Arun District Council
Arun Civic Centre
Maltravers Road
Littlehampton
West Sussex BN17 5LF
Planning & Building Control General Enquiries
Tel: (01903) 737756 Fax: (01903) 730442
Dx: 57406 Littlehampton
Minicom: 01903 732765
e-mail: planning@arun.gov.uk
website: www.arun.gov.uk/planning

Application No: P/161/21/HH
Site Address: 21 Pyrford Close Pagham PO21 3NL
Description of works: Erection of single storey rear extension, front porch, detached garage to side, shed in rear, conversion of loft to habitable use and alterations to fenestration/openings following the demolition of existing rear conservatories.

Thank you for your internet representation made on 3rd December 2021 which has been recorded as an objection with the comments as follows:

Sheet
Plans and Elevations as proposed

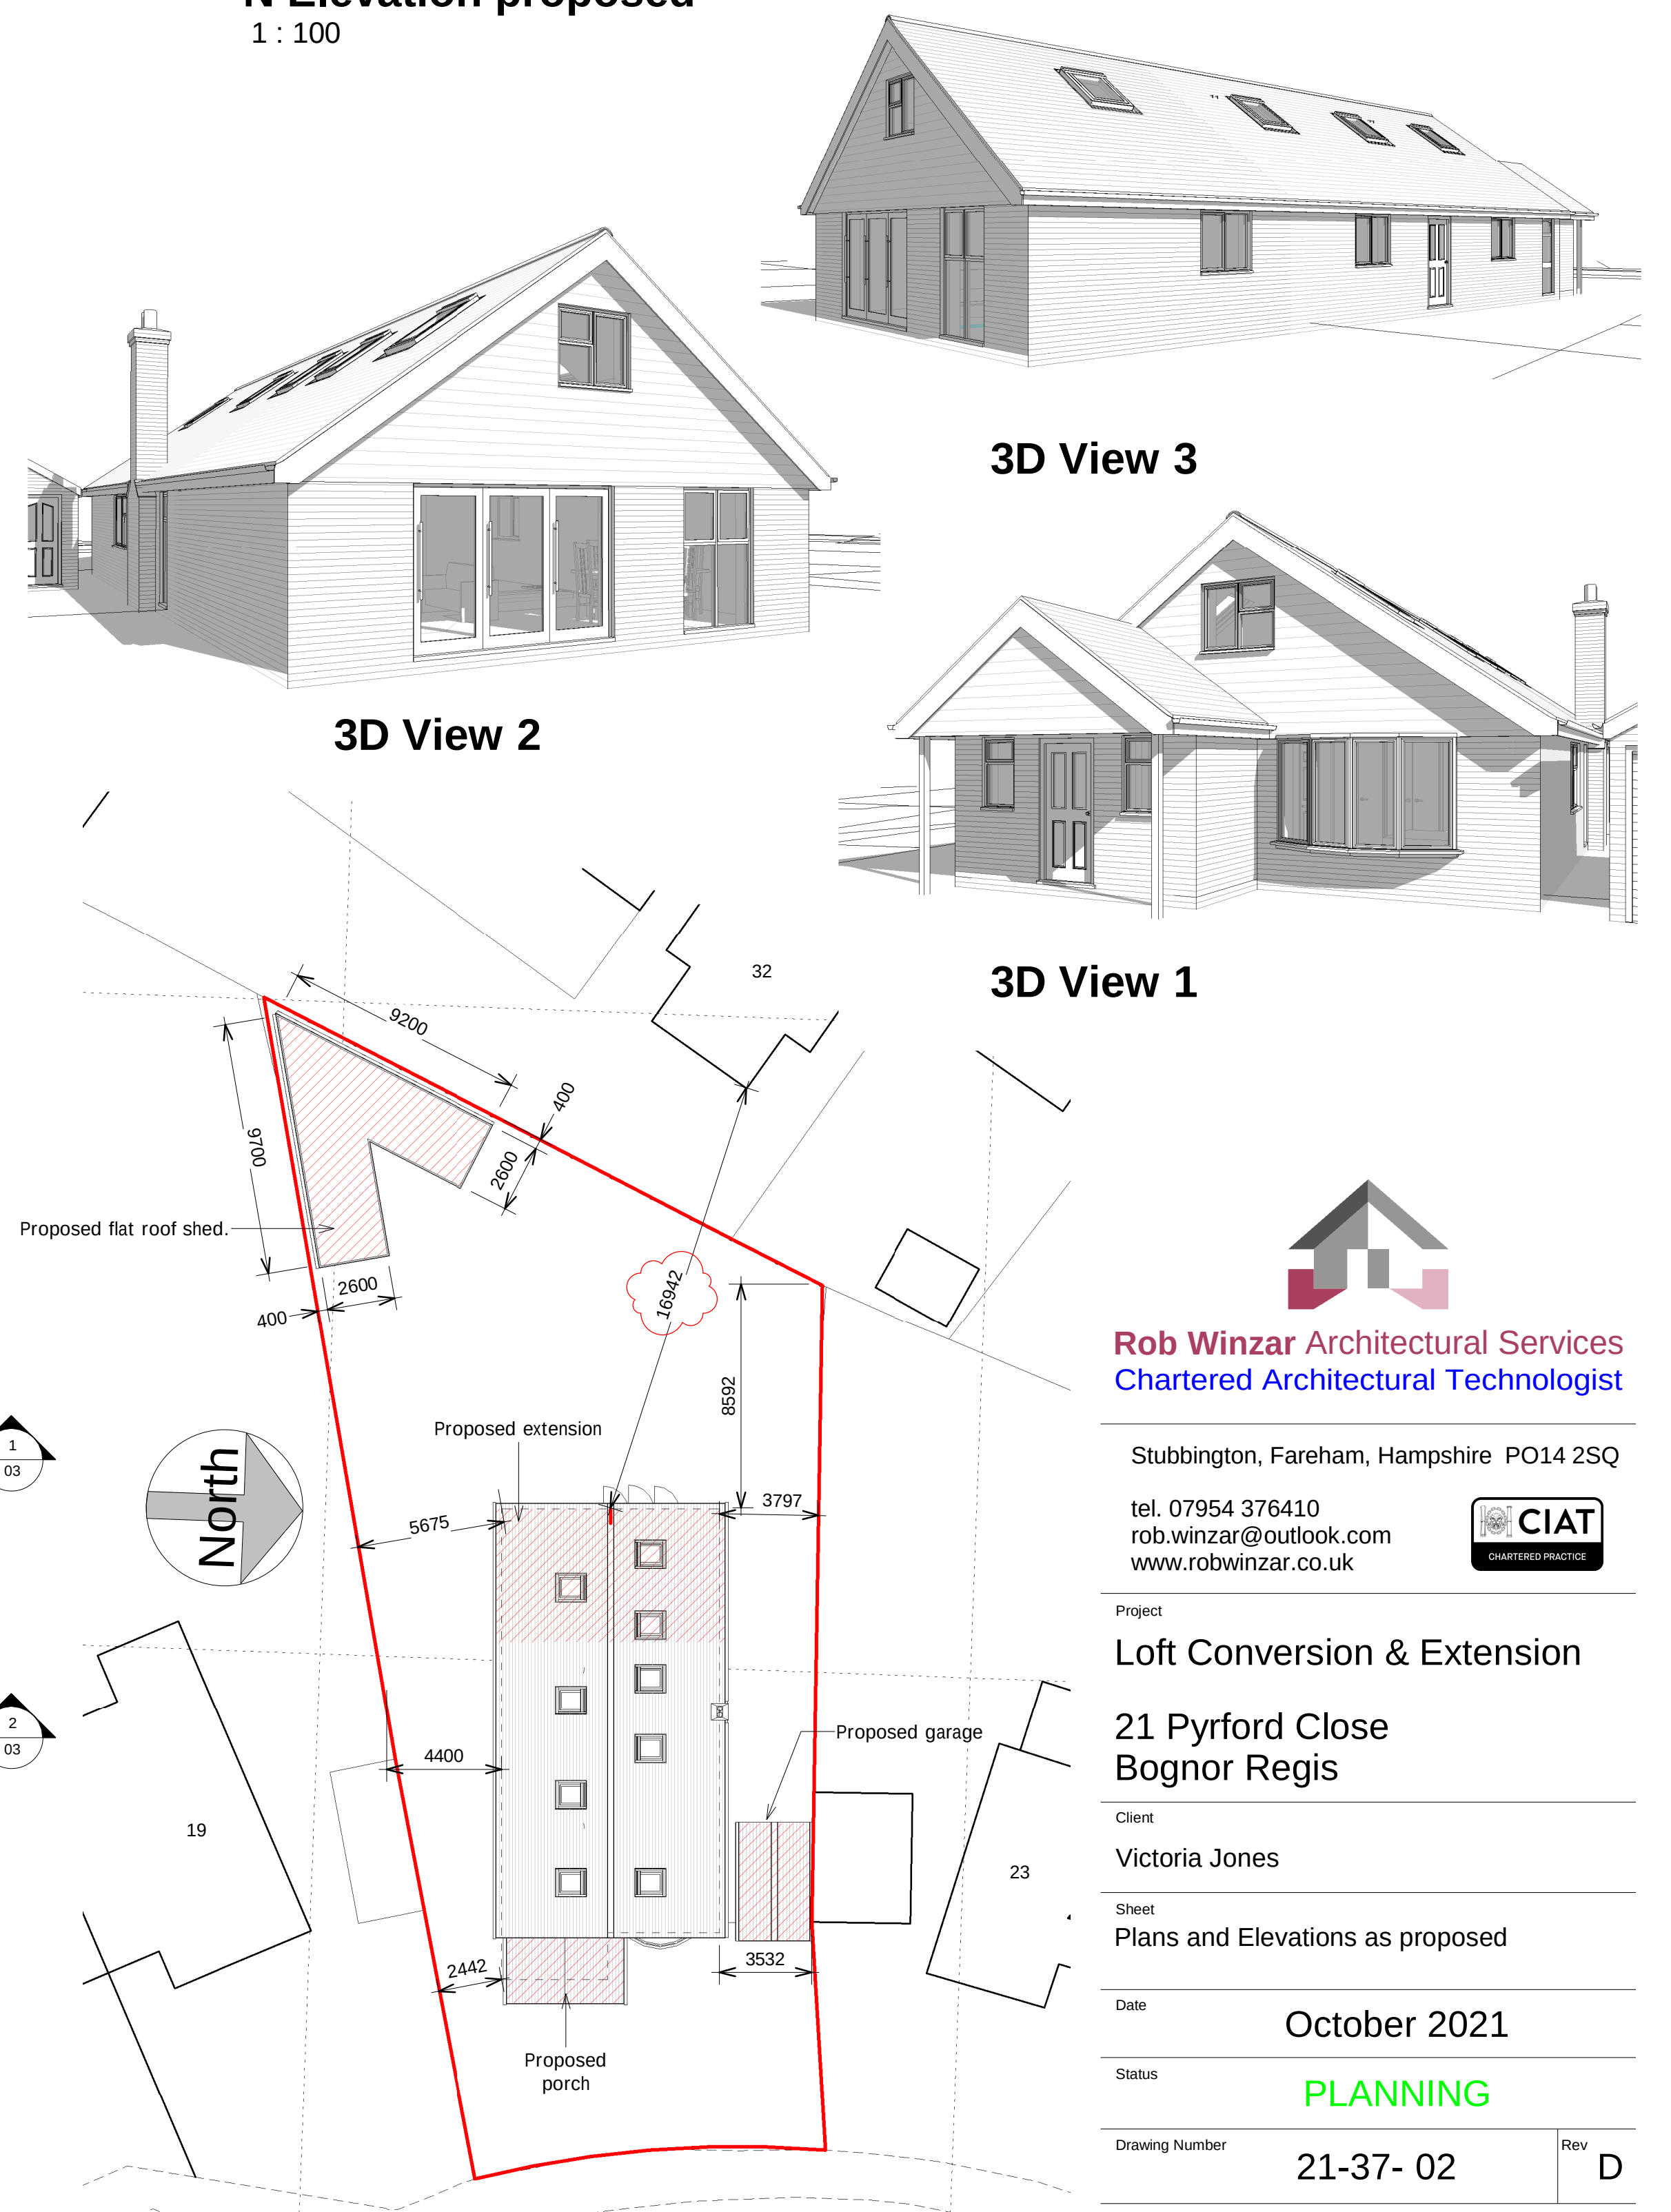
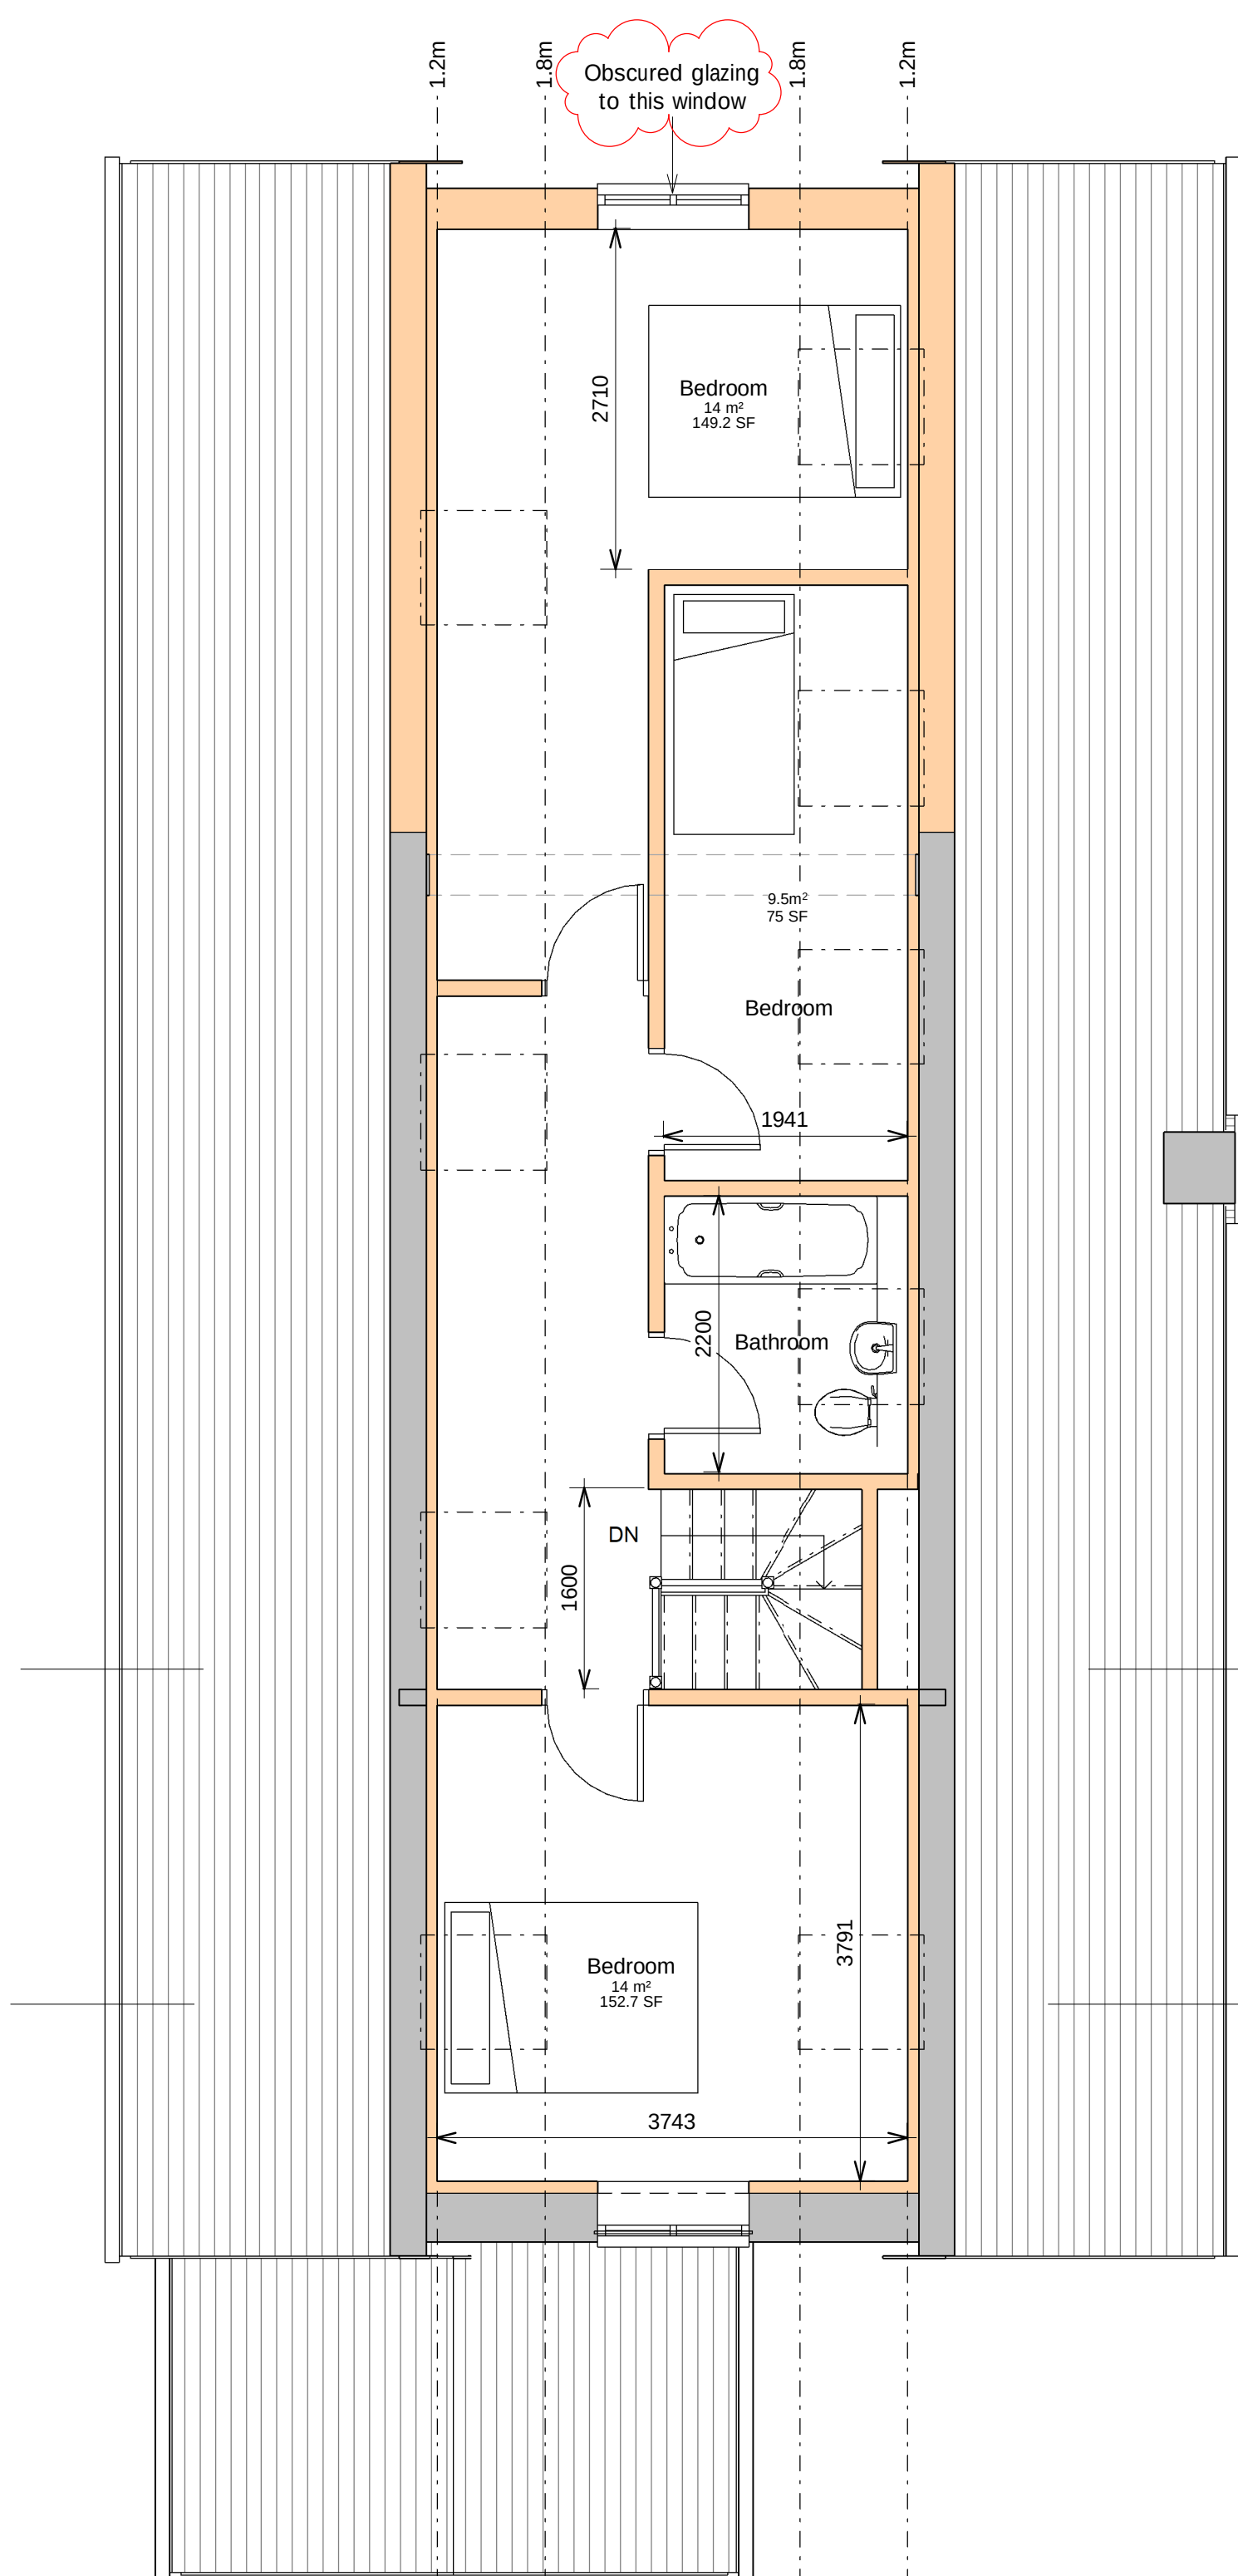
Our concern is windows in the loft conversion , and which
Direction they will face as we do not want to be overlooked
Into our garden and conservatory as our back gardens face
Each other and are extremely close.
We request a copy of the plans asap before we can make
Our final decision
